**Re: Objection to MP08_0244 MOD 1 Modification Request for Mixed Used Development at 23-37
Lindfield Avenue and 11 Havilah Lane, Lindfield**

PCU041615

1 SHADOW DIAGRAM - 21stDEC_9AM
5003 SCALE1 : 650

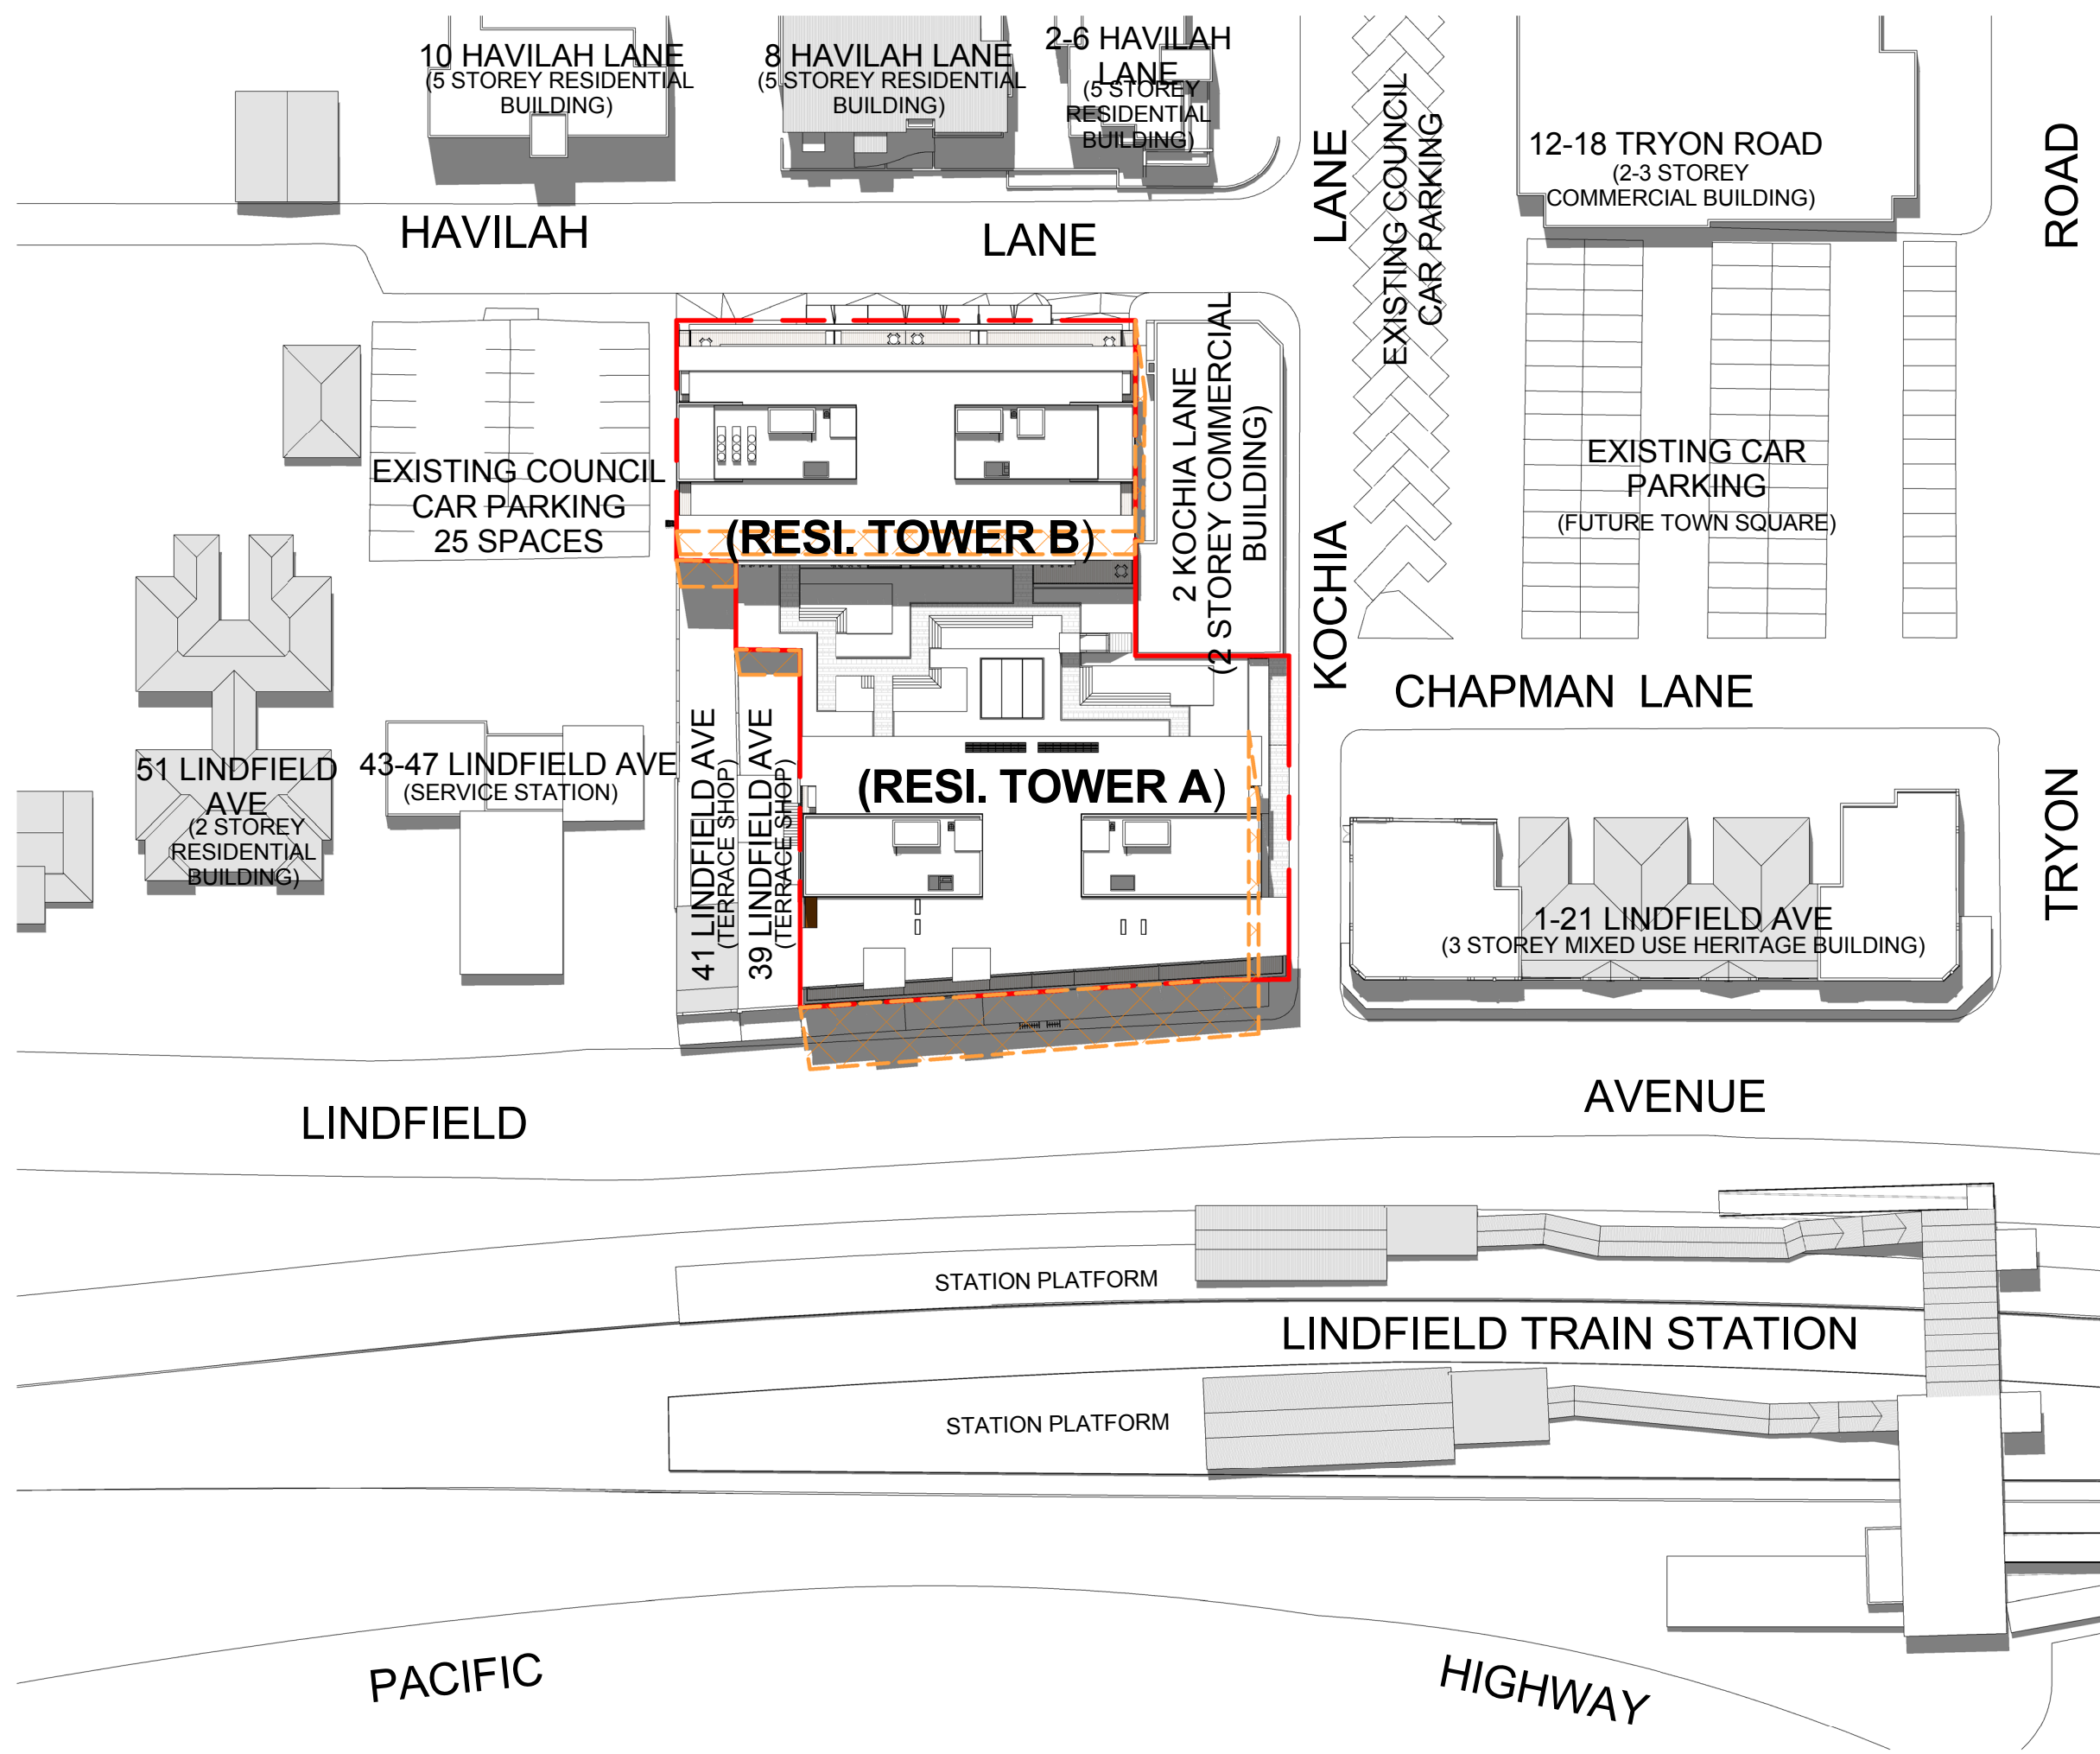
- The additional storeys create new adverse shadowing: a) for residents in the Havilah Lane apartments, particularly after 3pm b) for the popular outdoor café and central Lindfield hub area at 12 Tryon Road in afternoons, particularly in winter and c) for all commuters on the city bound Lindfield rail platform, instead of 50% of the year as approved, it will now be in shadow in the mornings 75% of the year

FIGURE 1.4 – MODIFIED SCHEME RETAIL LEVEL

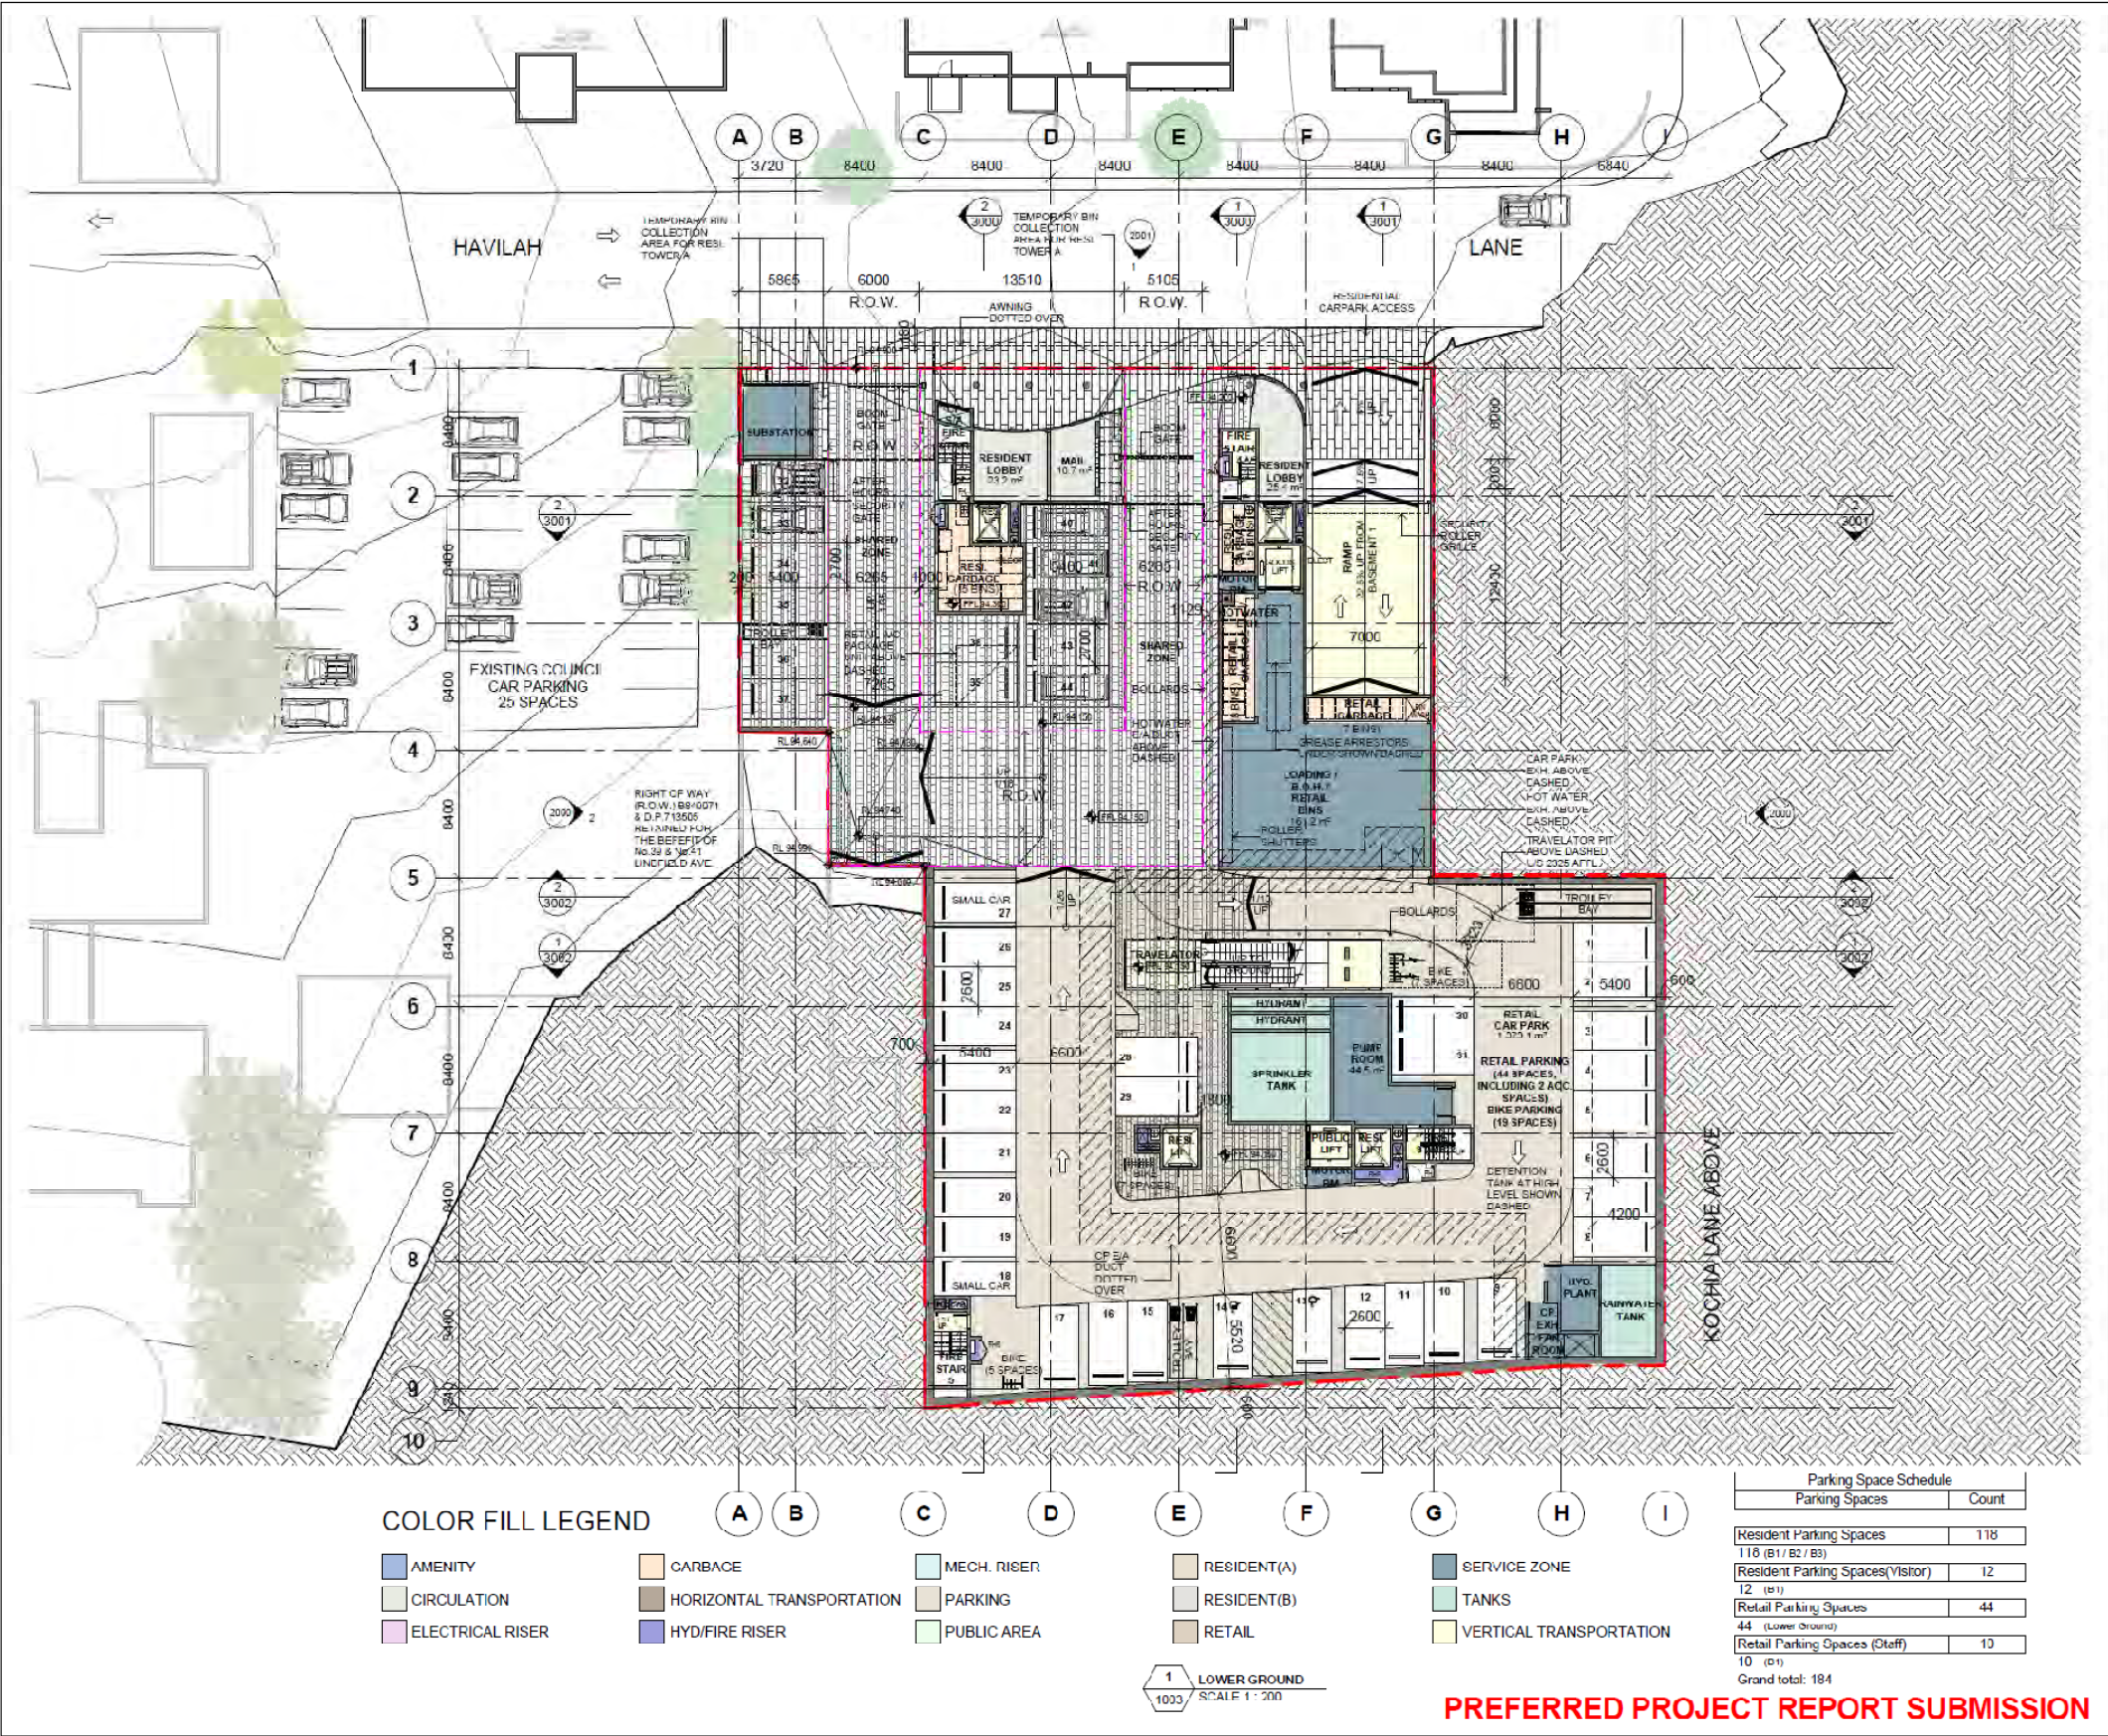
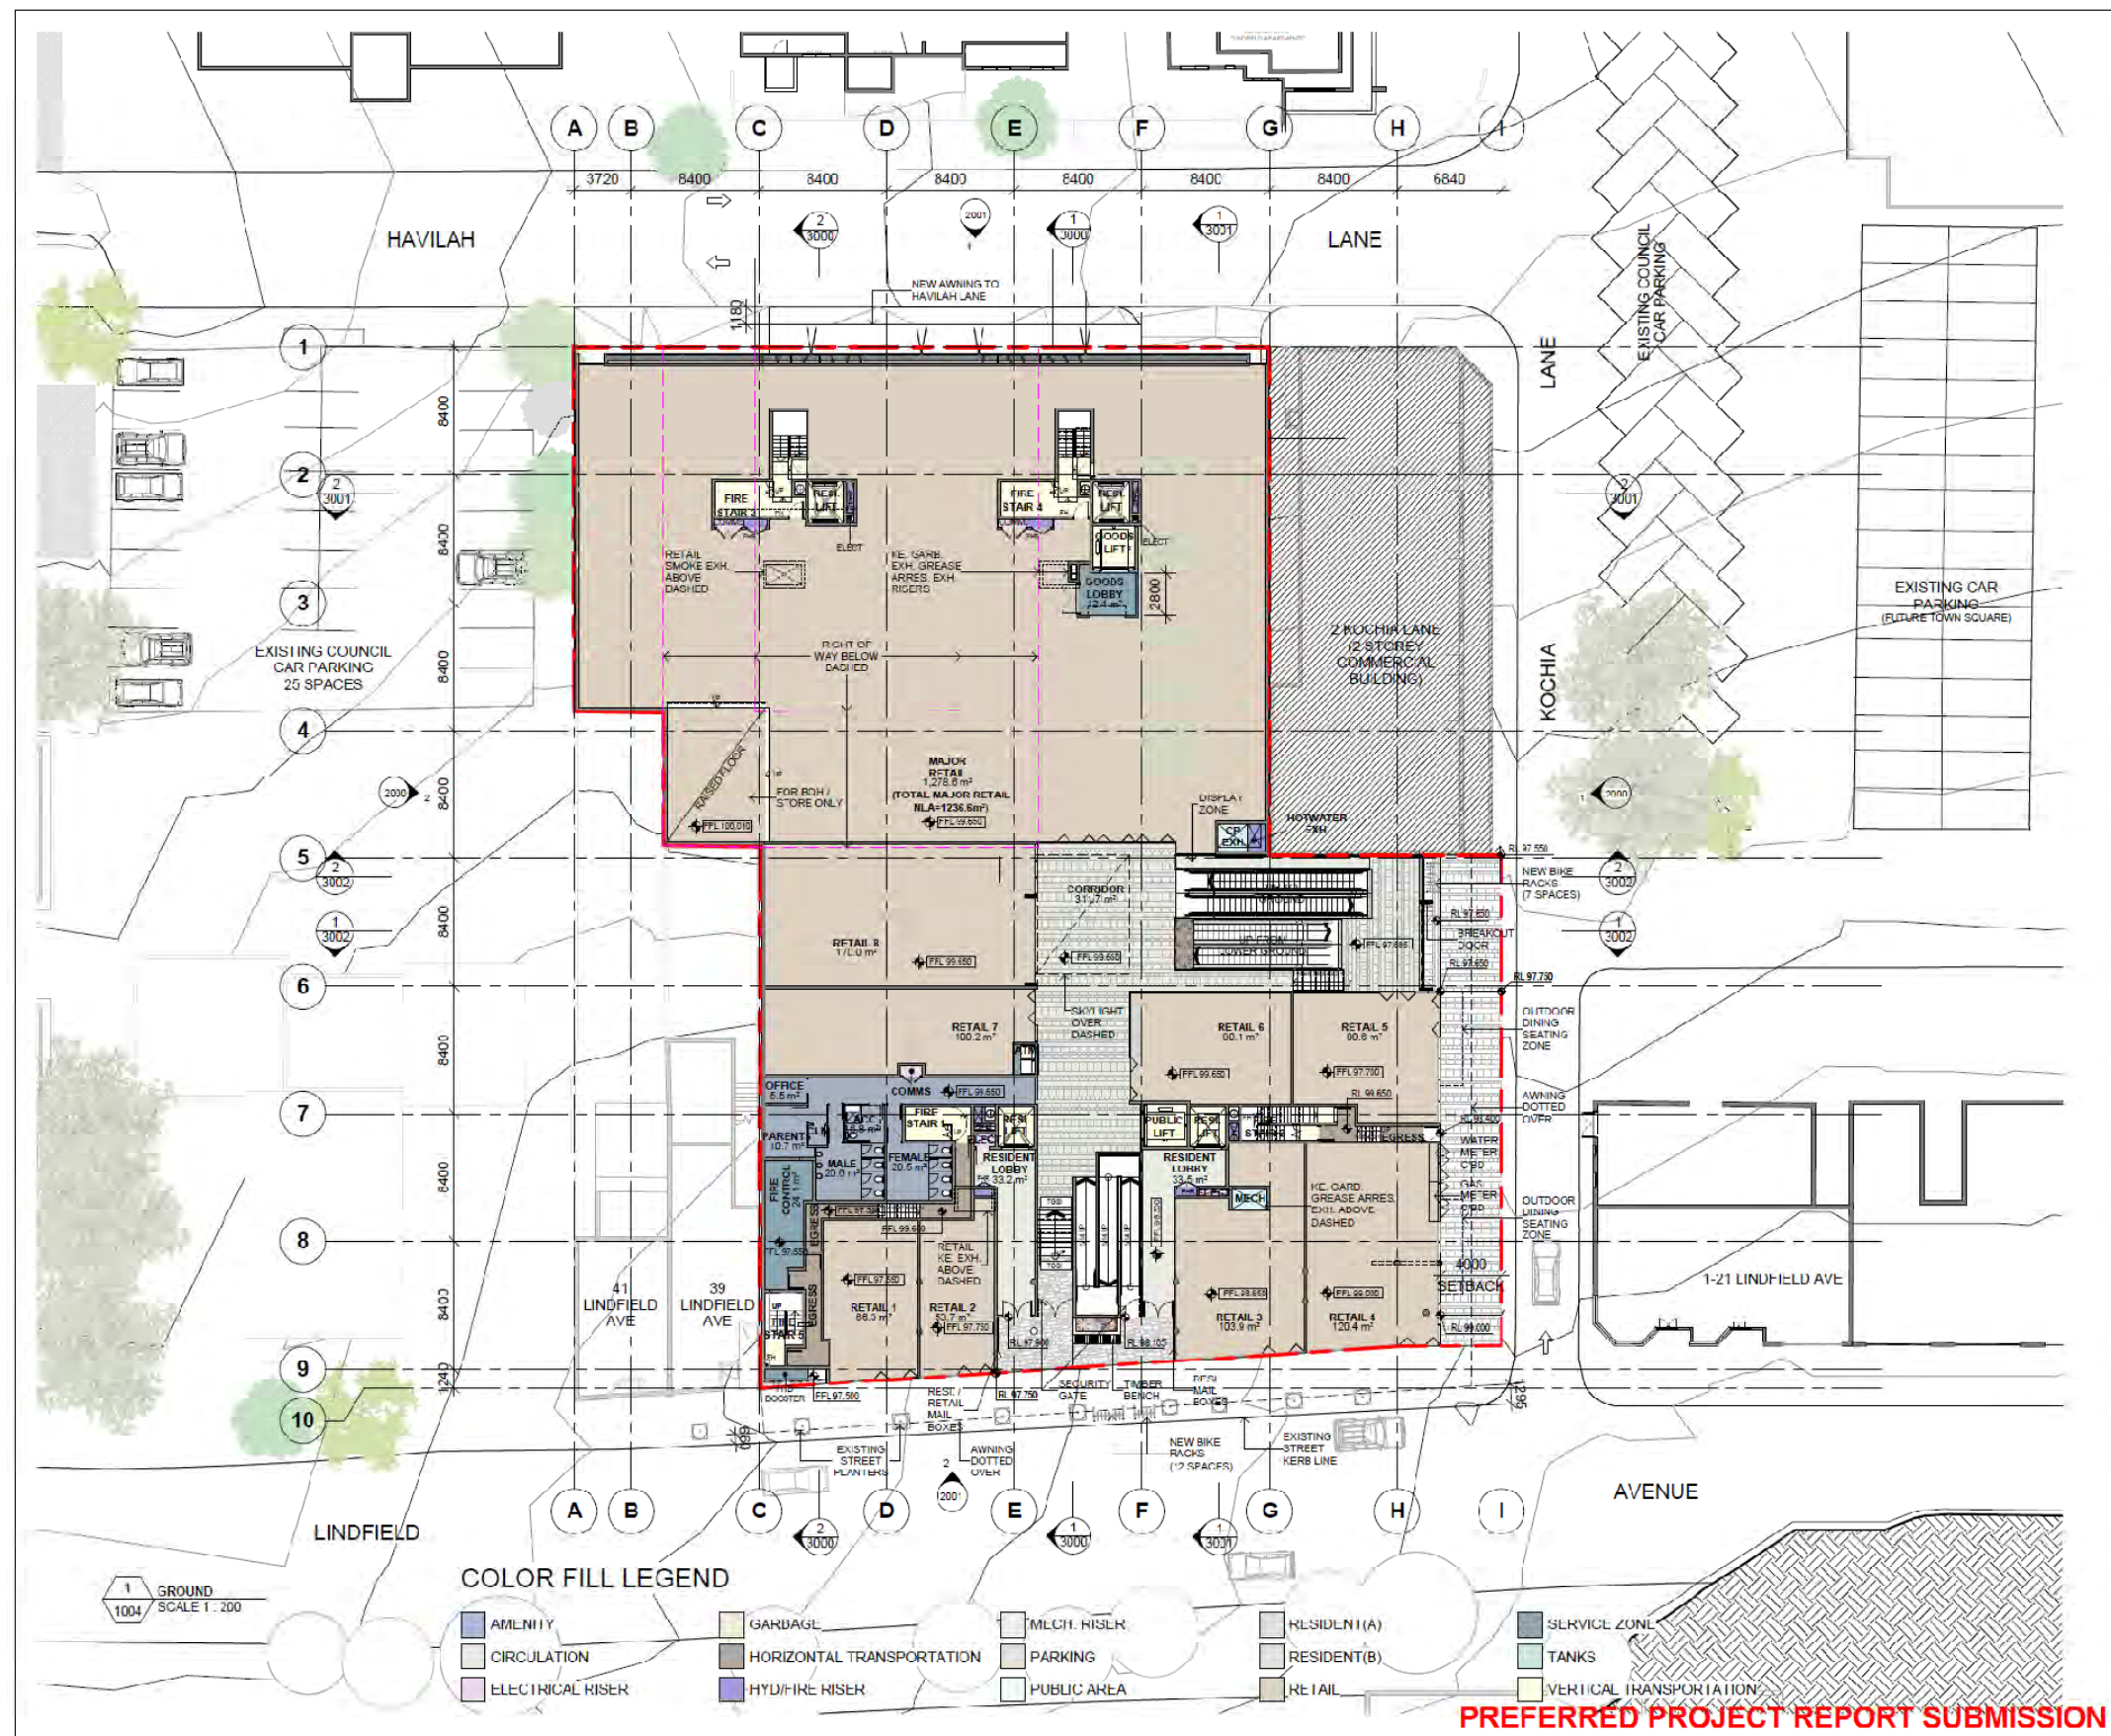
- Car spaces were identified as inadequate for the retail component and this has not been addressed relative to the remaining retail space proposed. The 25 car spaces counted as part of council's car park are also now highly uncertain due to the proposed rezoning and potential redevelopment.
